Appeal Decision

Appeal Ref: APP/R5510/W/24/3343680

260 Kingshill Avenue, Hayes UB4 8BZ

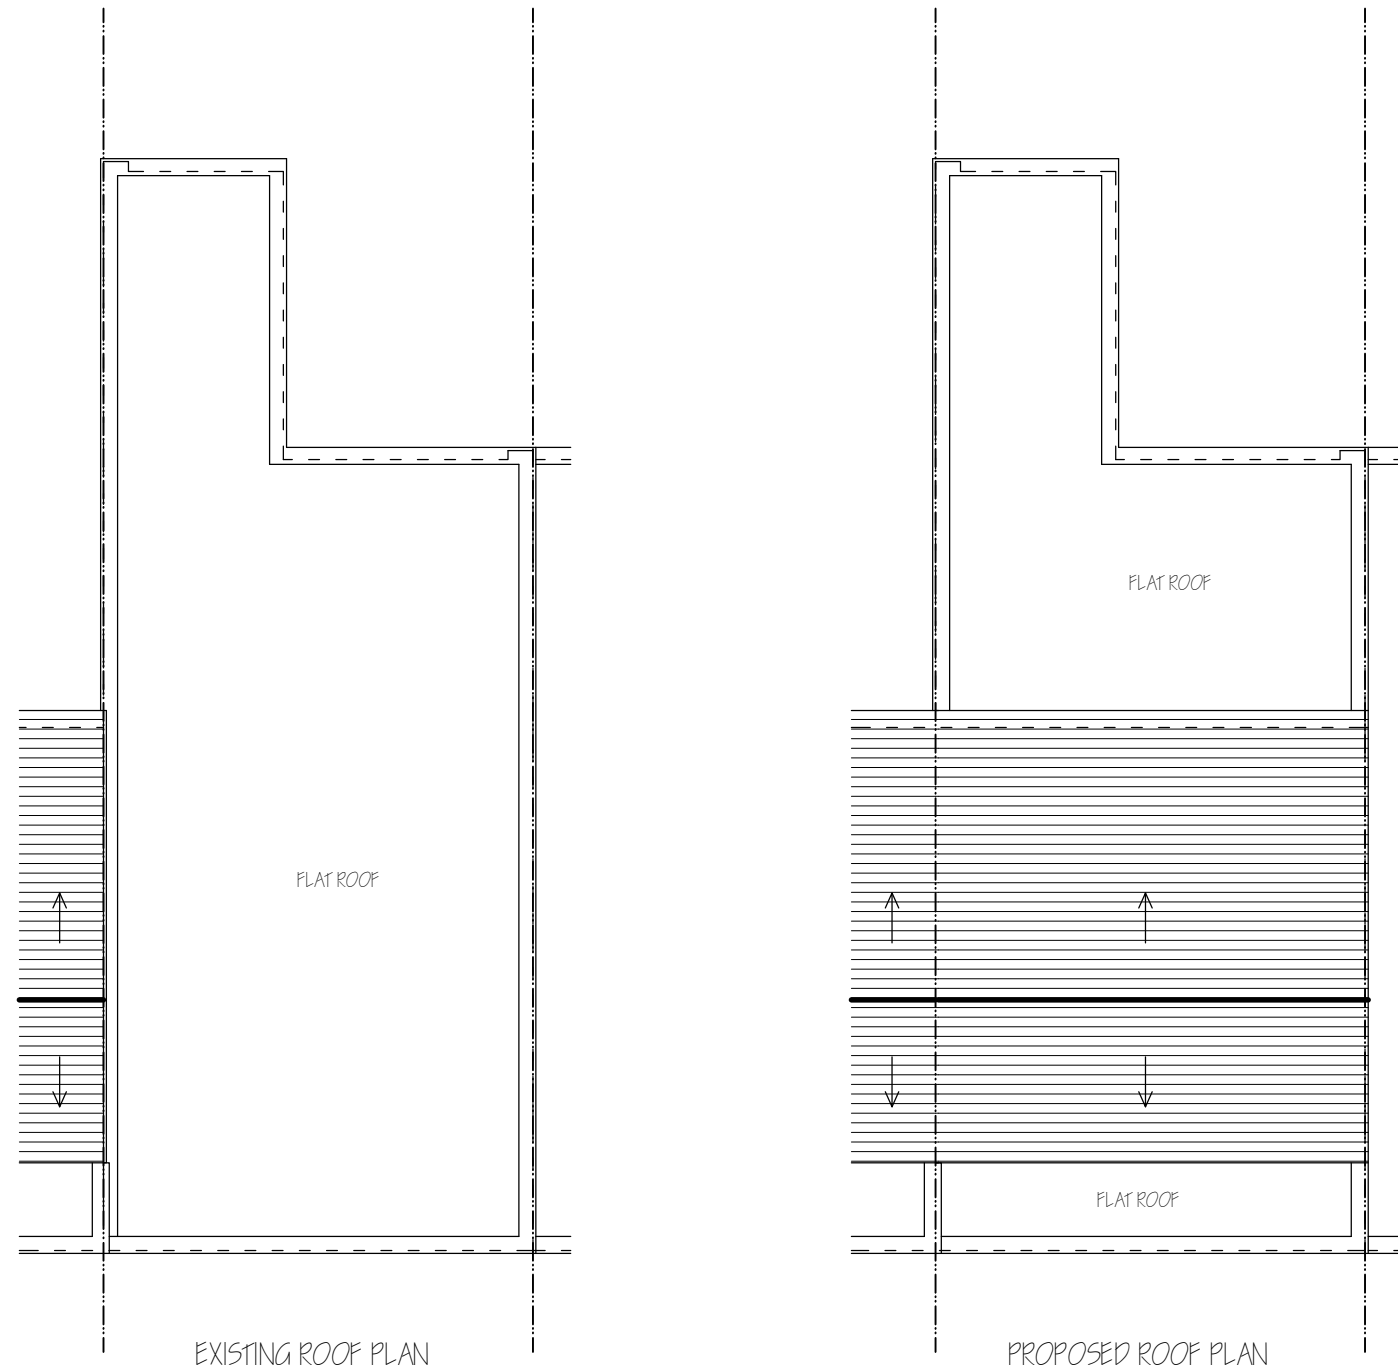
10. The grounds of appeal explain that the purpose of the proposed extension is to provide a watertight and weatherproof roof over the residential accommodation below and to achieve additional domestic storage in the attic thereby created. However, the appellant's agent will be aware that modern building technology professionally implemented can now achieve secure and waterproof flat roofs. The storage issue is a drawback of a refusal but not of sufficient weight to overcome the design flaws of the scheme.

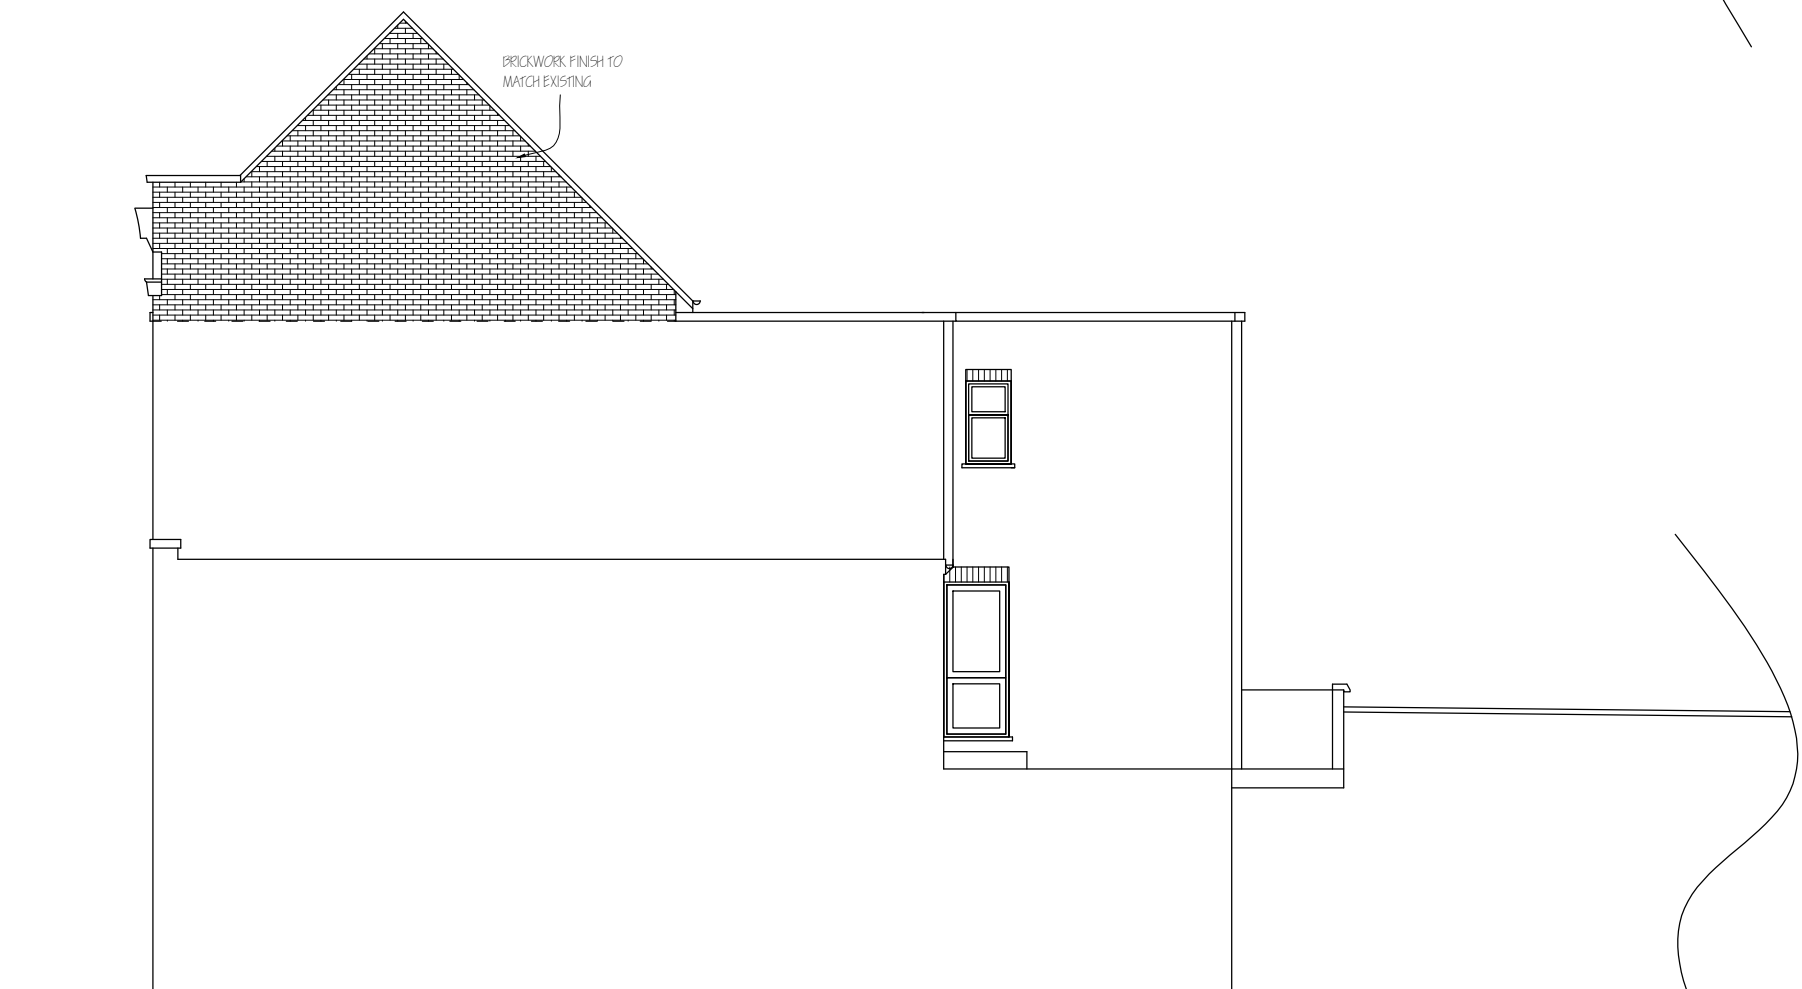
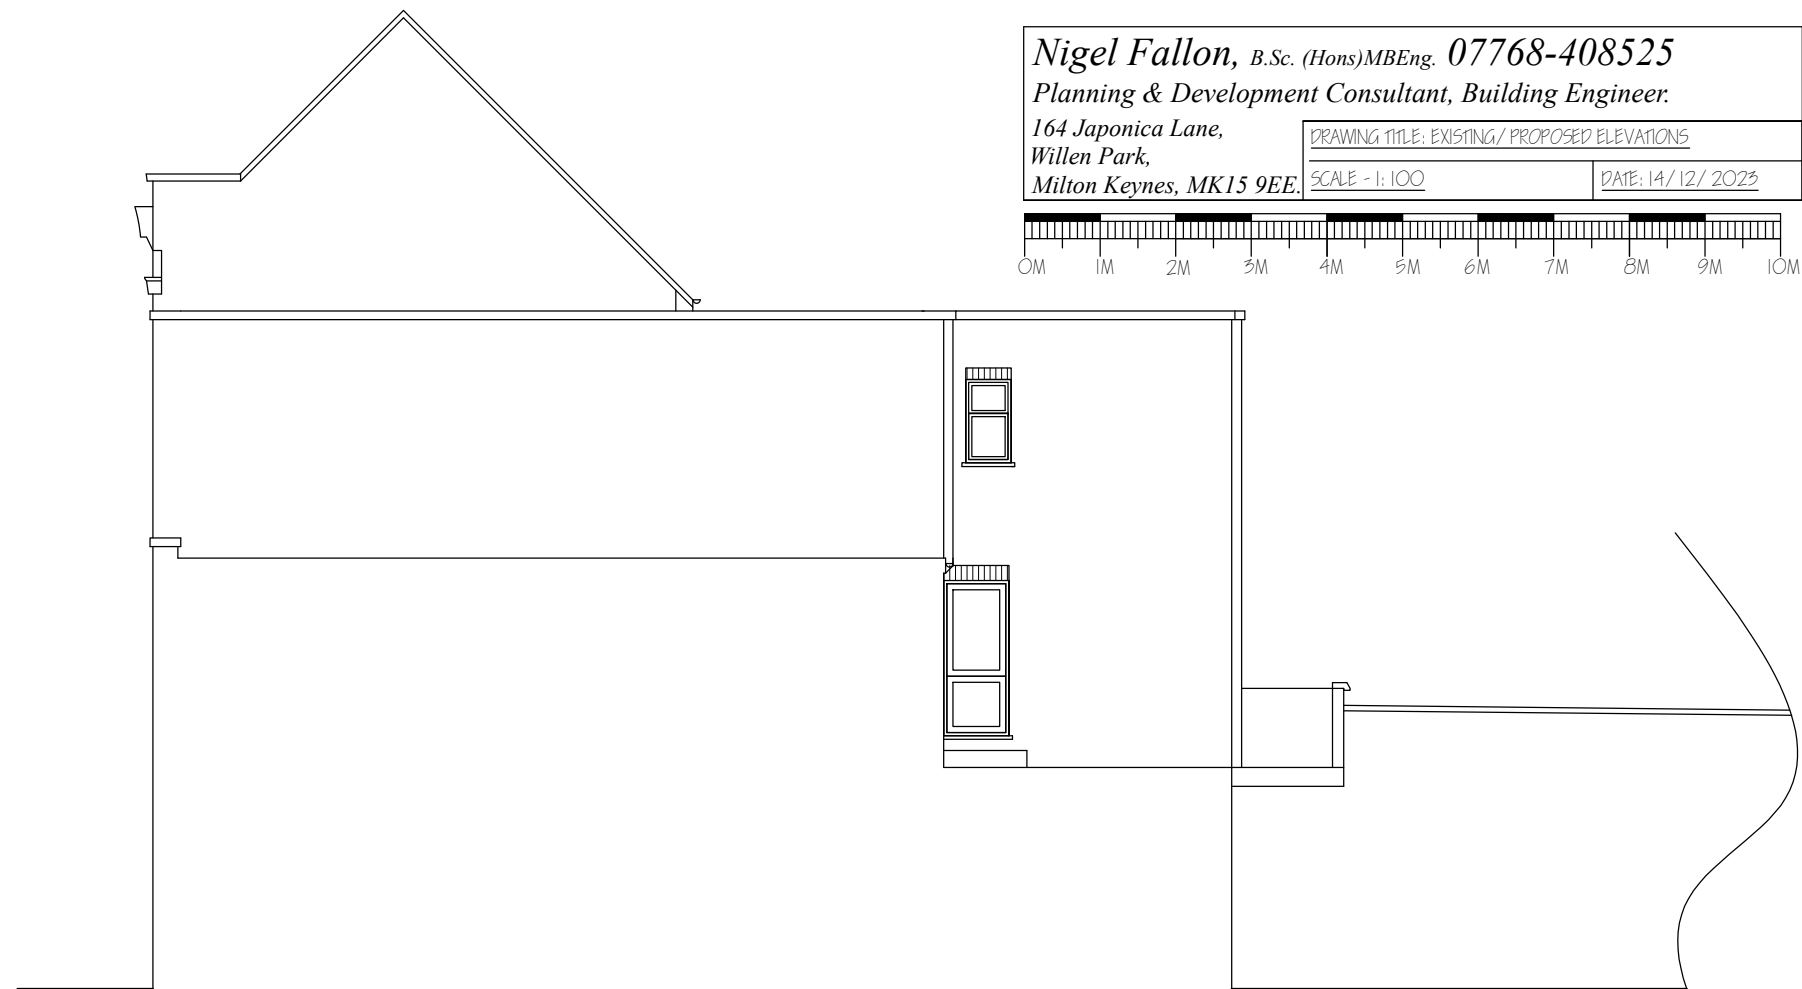
4. The appeal building is also three storeys but with a flat roof below the parade's projecting eaves/parapet and with its first and second floor windows set below the fenestration of the premises in the parade. In this position at No. 260, it serves as a transition between the parade and a two storey flat roof 1960's terrace of nine commercial units. The appeal scheme seeks to increase the height of the front elevation by 1.7m and erect a pitched roof with a gable end.

5. The C20th inter-war period design of the parade and in particular its symmetry is of particular merit, whilst because of its adjacent position the appeal building is inevitably constrained as regards alterations and additions. The limited scope of the submitted plans with their cut off point on the boundary does not aid their interpretation, but it would appear that the intention is for the proposed pitched roof to match that of the parade in terms of its scale, design and external materials.

6. Ostensibly this brings with it a degree of visual harmonisation between No. 260 and the parade and I note that the grounds of appeal suggests that this would result in an improved link between the parade and the 1960's units, rather than be incongruous as the Council suggests. However, I consider that this increase of harmonisation is entirely the wrong design approach.

7. The parade with its distinctive period design is a visual entity and the existing flat roof of No. 260 provides the necessary contrast with it to act as a 'full stop' in the views from Hayes Road. As such, even without in itself having particular architectural merit, the property successfully achieves a transition between the parade and the 1960's terrace.

8. This was explained by the Inspector in the previous appeal who observed that as a step down in design terms, the appeal building works because it is '*currently subservient to the higher part of the terrace and is not dominant with regard to the lower part*'. I consider that in the current proposal the addition of the roof would introduce a confusion of design and scale that would be particularly harmful to the parade and overall have a negative effect on the character and appearance of the street scene of this part of Kingshill Avenue.
